RE: Modification 2 Stadium Members Facilities to Sydney Football Stadium (SSD 9249 and SSD 9835) 40-44 Driver Avenue, Moore Park

Thank you for your referral dated 10 August 2020, inviting comments from the Heritage Council of NSW on the above modification to the State Significant Development (SSD 9249 and SSD 9835) proposal.

Figure 1 - Stadium Fitness Facilities Proposed Location

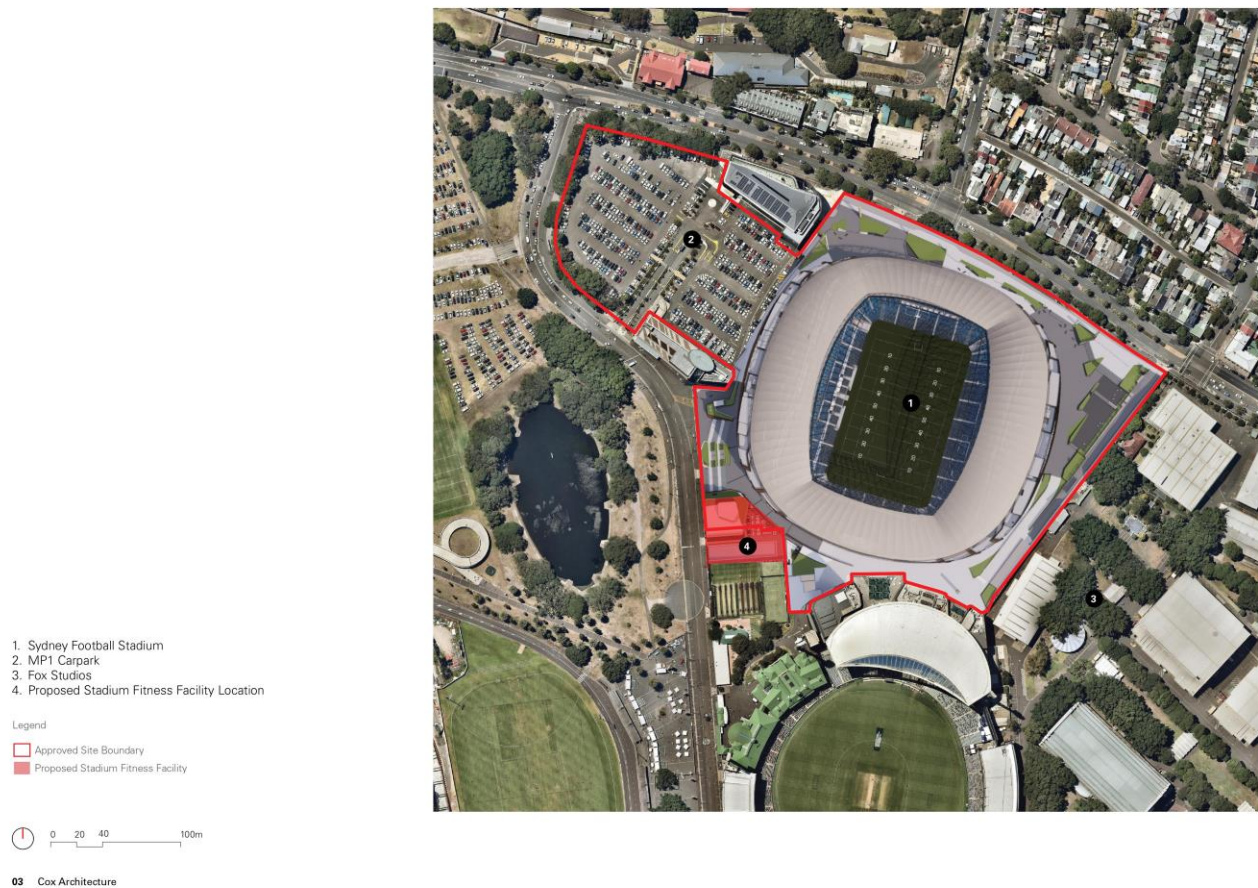
- The proposed amendments do not occur within the SHR curtilage of *Sydney Cricket Ground – Members Stand and Lady Members Stand*. However, the proposed fitness facility would impact on the greater setting of the SHR item and on views to and from the SHR listed members stand.

- The proposed boundary amendment would encroach on Lot 12, DP 1255013, which includes the SHR item *Sydney Cricket Ground – Members Stand and Lady Members Stand*. However, it is noted that most of the use of the amended proposal in the vicinity of the members Stand is used for managing crowd entry. It is recommended that this facility be designed to mitigate any visual impact by keeping the enclosers as transparent as possible.
